EL PASO COUNTY STORMWATER MANAGEMENT PLAN CHECKLIST

EPC Project Number: PPR-22-62

SHEET TITLE:
OVERALL SITE PLAN

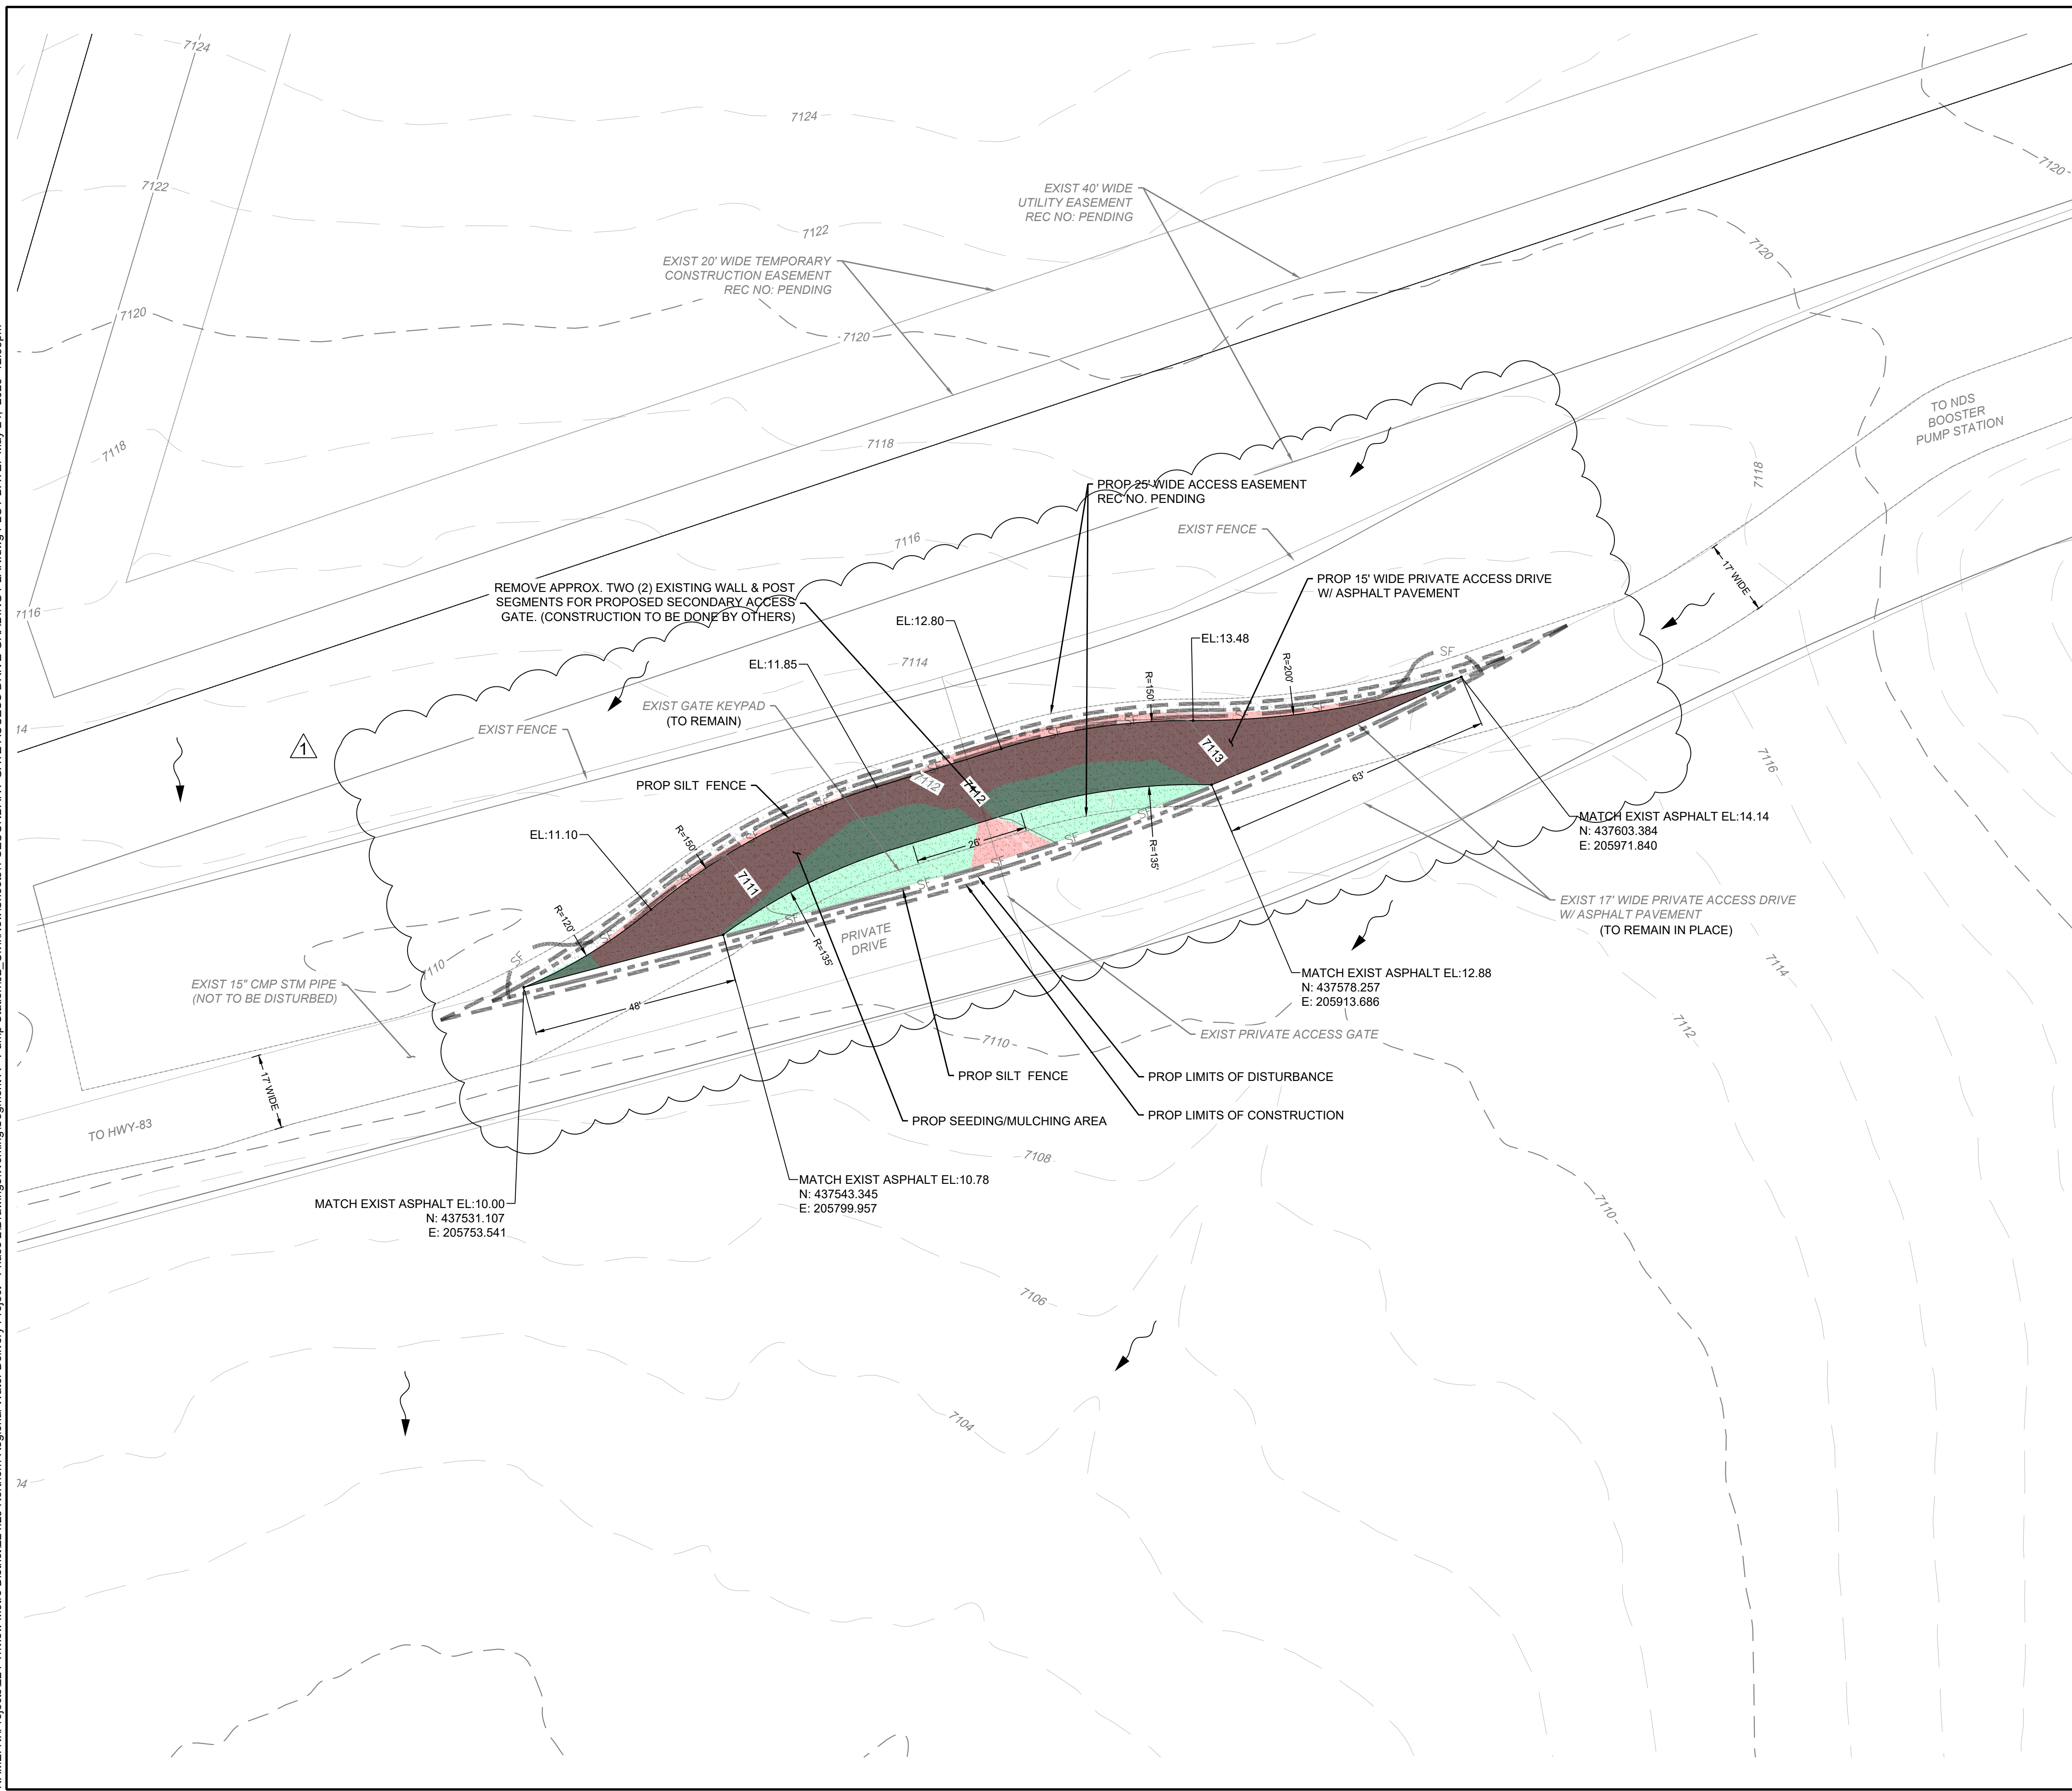
Applicant	EPC
17	SWMP Map to include: reviewed GEC_v1	X	
17a	construction site boundaries		✓
17b	flow arrows to depict stormwater flow directions		X
17c	all areas of disturbance		✓
17d	areas of cut and fill		X
17e	areas used for storage of building materials, soils (stockpiles) or wastes		✓
17f	location of any dedicated asphalt / concrete batch plants		✓
17g	location of all structural control measures		✓
17h	location of all non-structural control measures		X
17i	springs, streams, wetlands and other surface waters, including areas that require maintenance of pre-existing vegetation within 50 feet of a receiving water		✓
18	Narrative description of all structural control measures to be used. Modifications to EPC standard control measures must meet or exceed County-approved details	X	X
19	Description of all non-structural control measures to be used including seeding, mulching, protection of existing vegetation, site watering, sod placement, etc.	X	X
